From: Graham Evans
Sent: 29 September 2011 10:27
To: Planning.Responses
Subject: FW: Planning Consultation on: BR/239/11/

APPLICATION BR/239/11/

Site The Beach The Esplanade Bognor Regis PO21 1SY

Description of Works: Conversion of existing nightclub premises into two town houses & ten apartment flats

GROUND FLOOR PLAN
AS PROPOSED

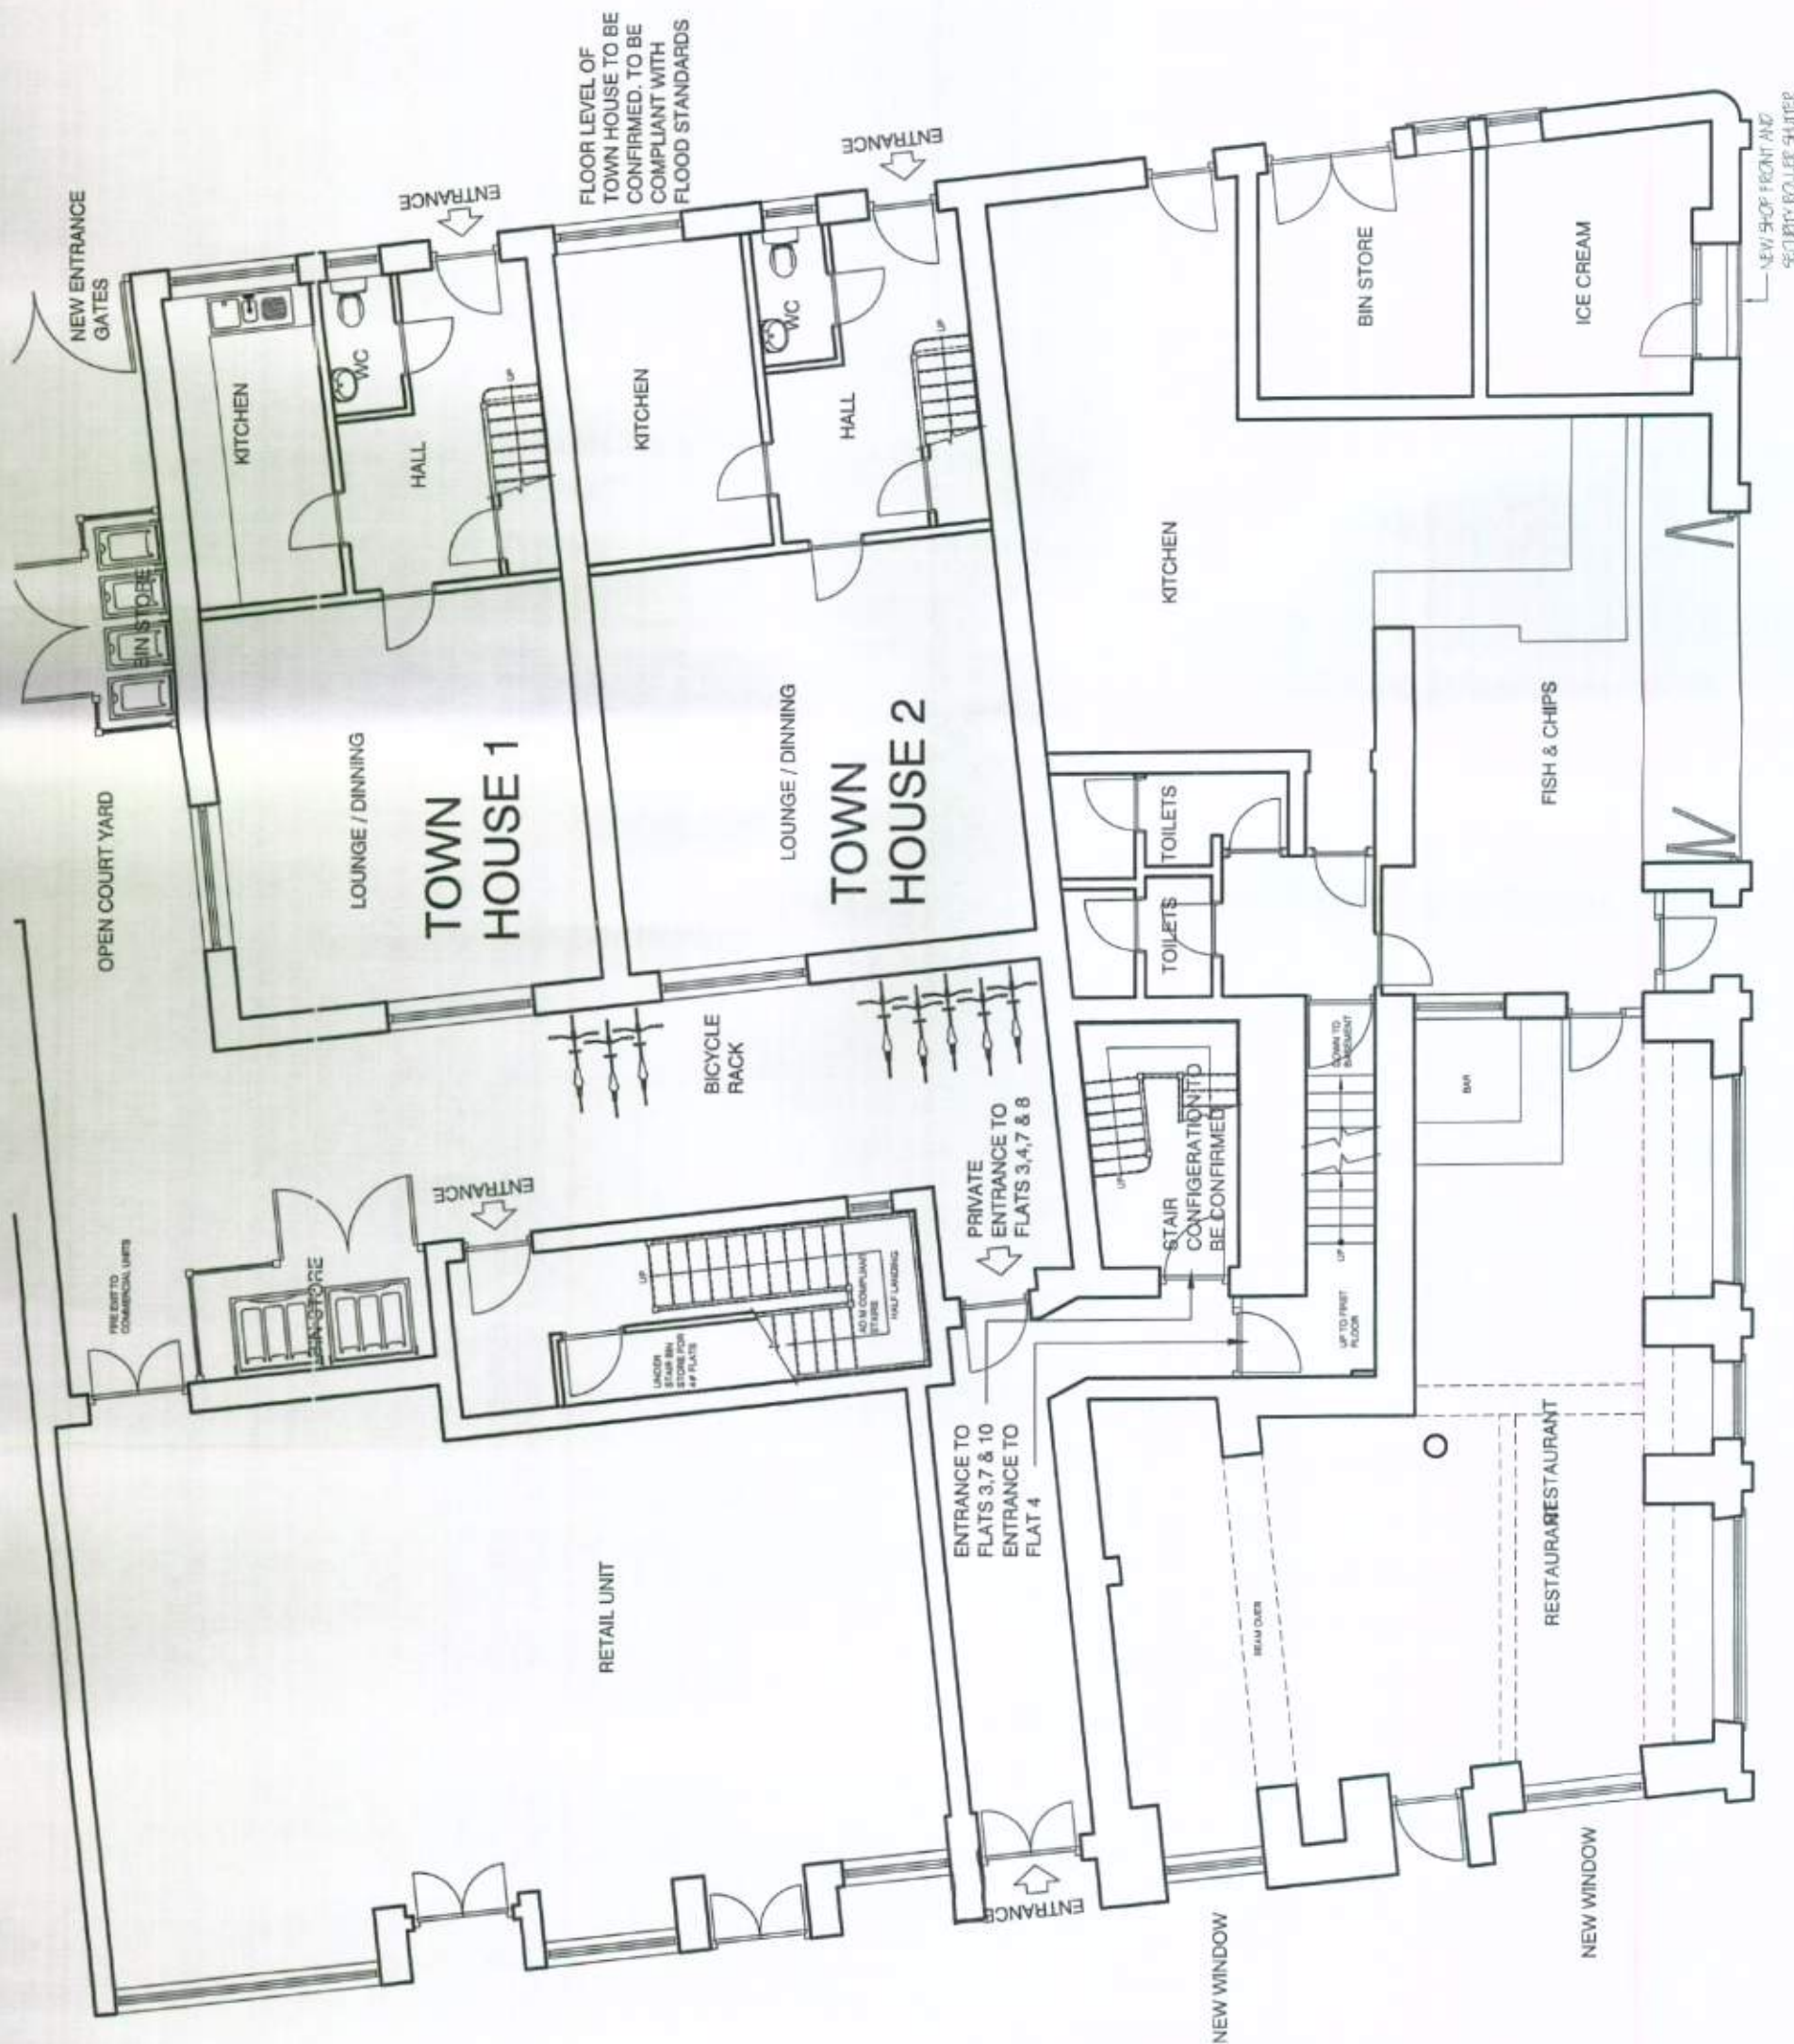
In addition there is potential for noise from existing adjoined commercial uses to impact upon adjacent residential units. Insufficient detail is available in respect of the proposed & existing structure of partitions between commercial and residential uses and their attenuation of the passage of sound.

FIRST FLOOR PLAN
AS PROPOSED

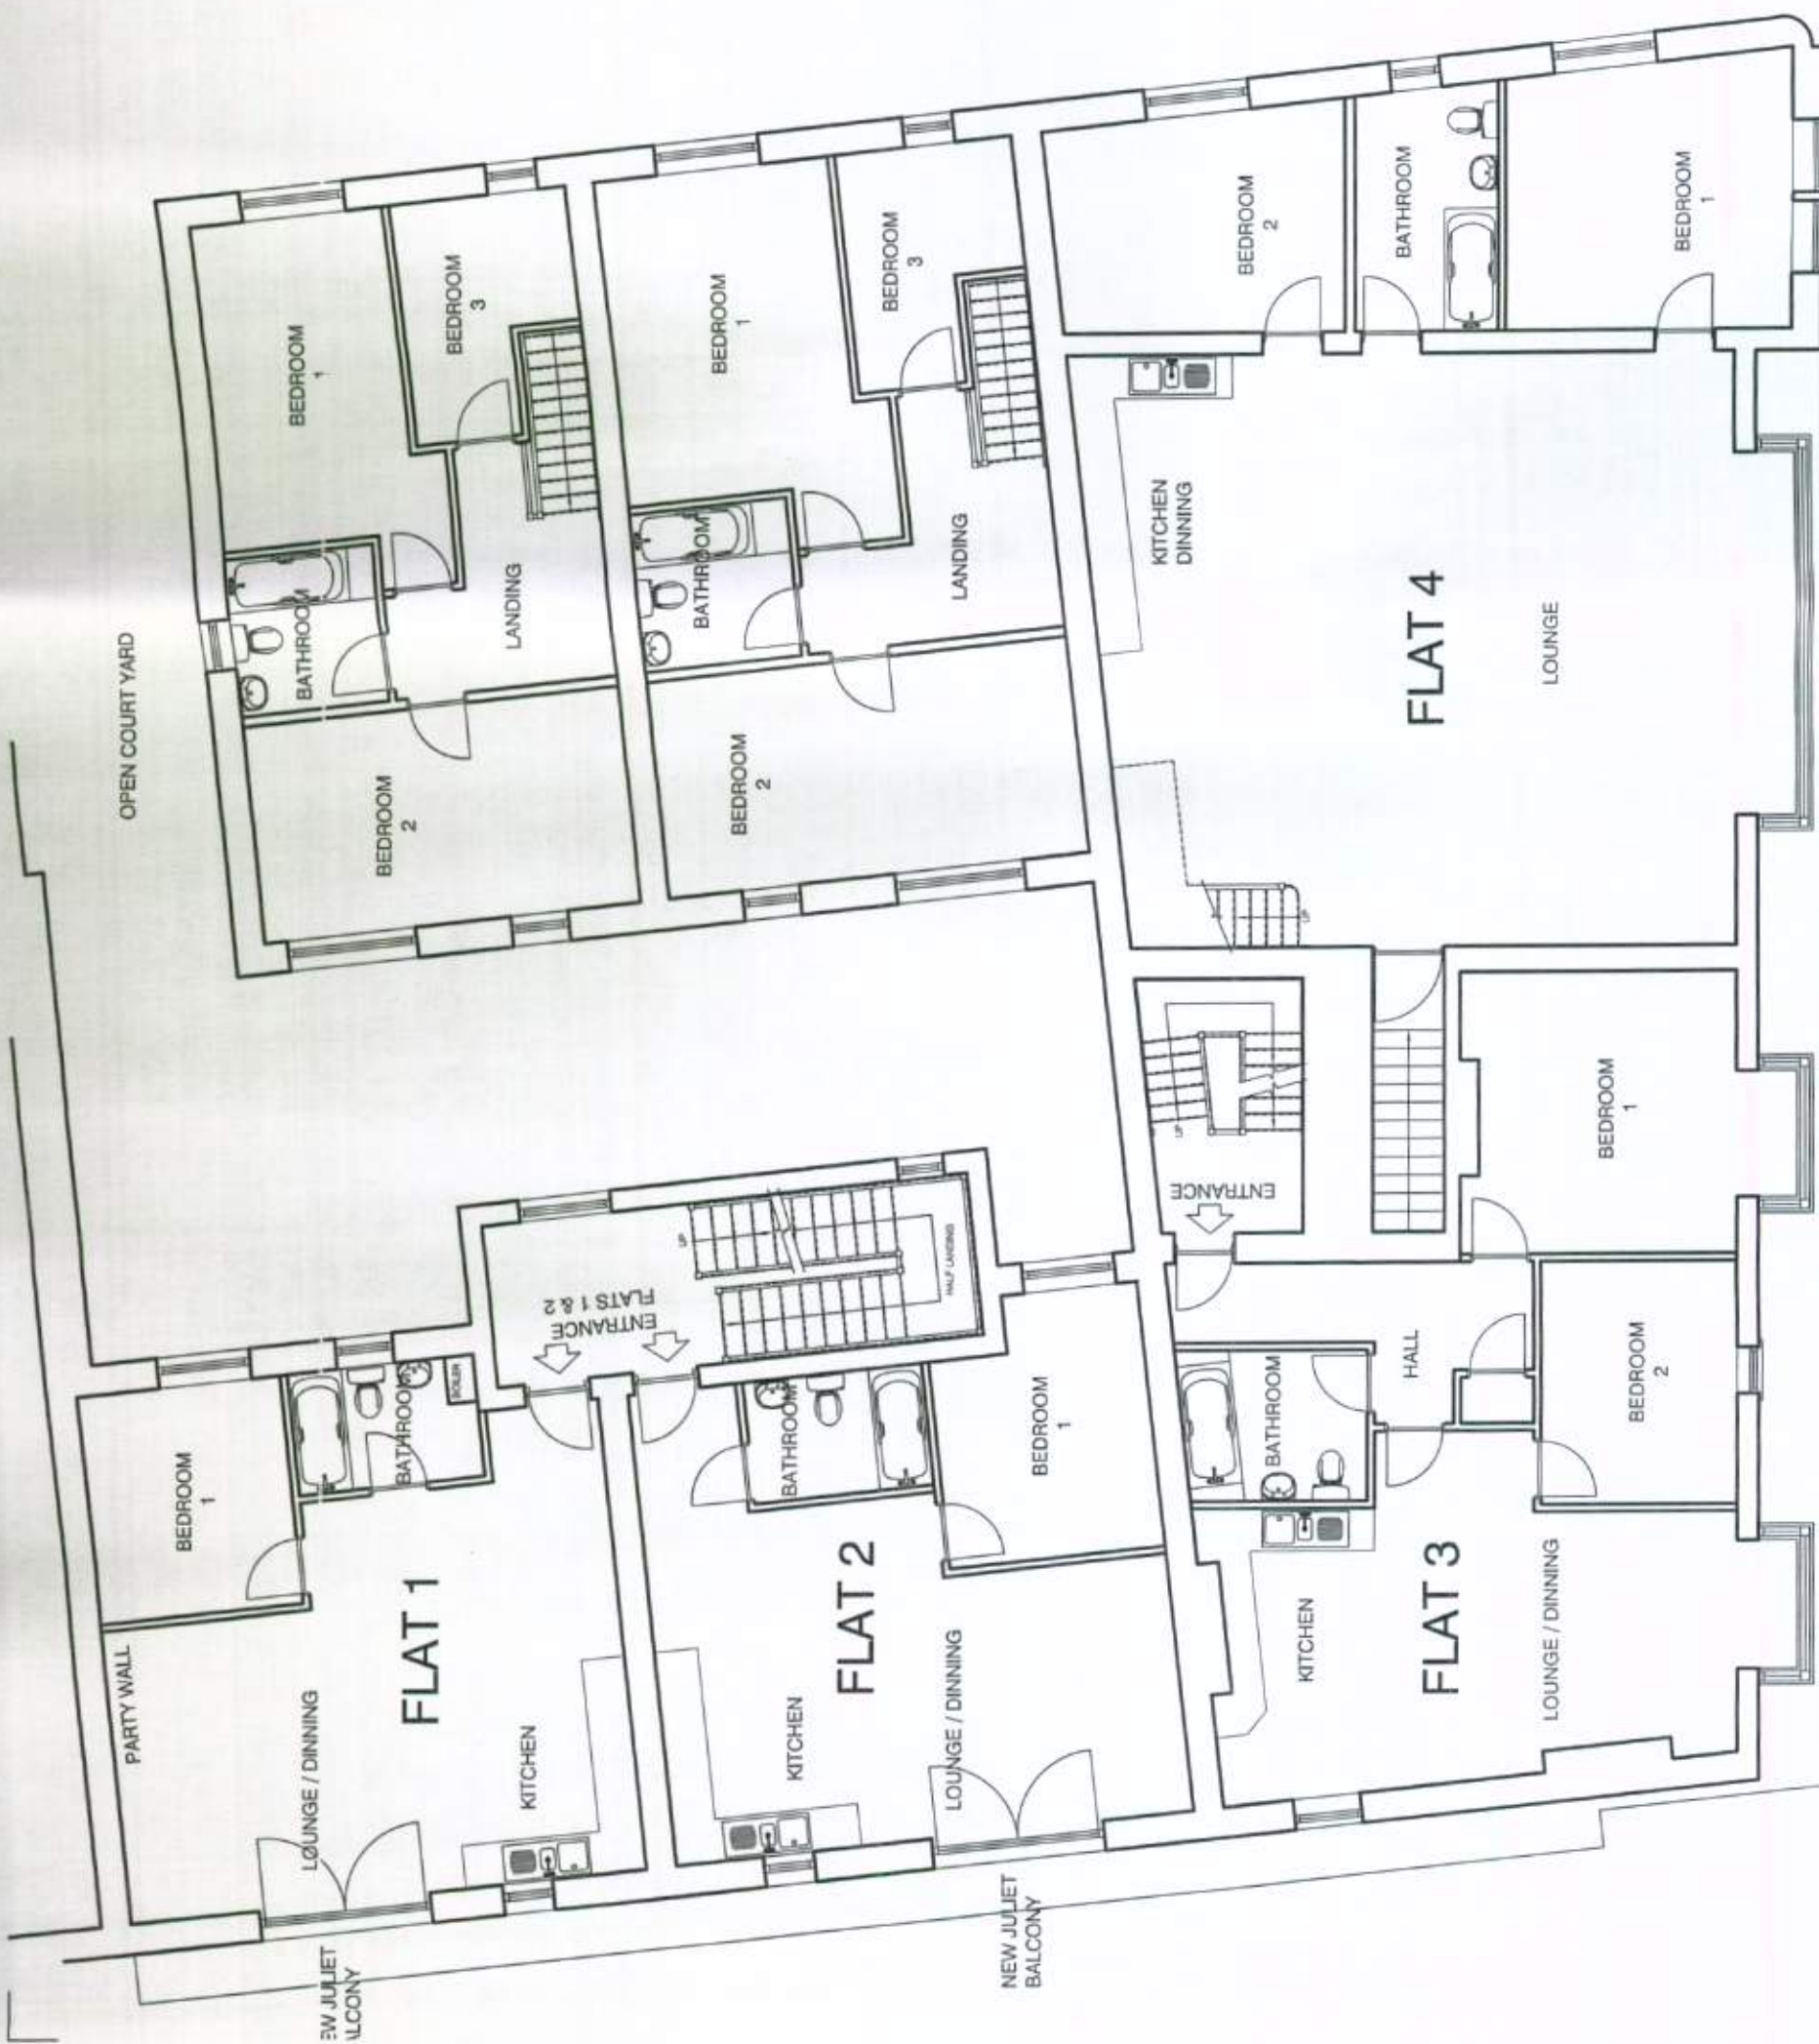
Means of escape in the event of fire from the flats is not acceptable as escape is via other rooms of significant risk, this could be mitigated by means of escape windows at 1st floor but not at floors 2 and 3.

A number of the bedrooms fail to meet a minimum acceptable room size of at least 7 sqm

Where flats have 2 bedrooms then bedroom 1 is to be at least 10 sqm and bedroom 2 at least 7 sqm, with a combined living kitchen space of 23 sqm

where there is only 1 bedroom then the combined living space for the kitchen and living room is to be at least 14.5sqm
